Application for Planning Permission for Works or Extension to a Dwelling

Development: Replace timber windows with PVC windows. (This application may affect the character and appearance of the Arundel Conservation Area).

Location: 8 Nineveh Shipyard Arundel BN18 9SU

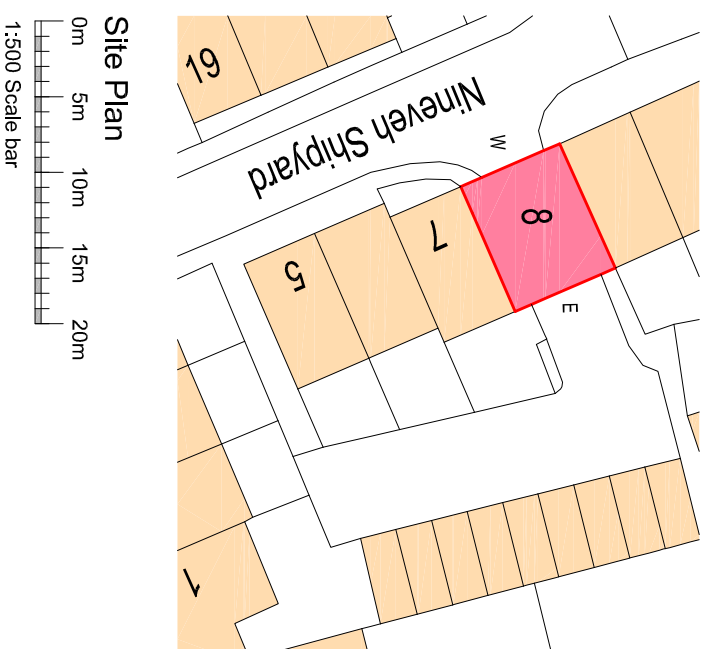
The location plan requires a solid red outline around the site boundary, please review and amend. Further details of what must be included on the plan can be found in the Validation Requirements List.
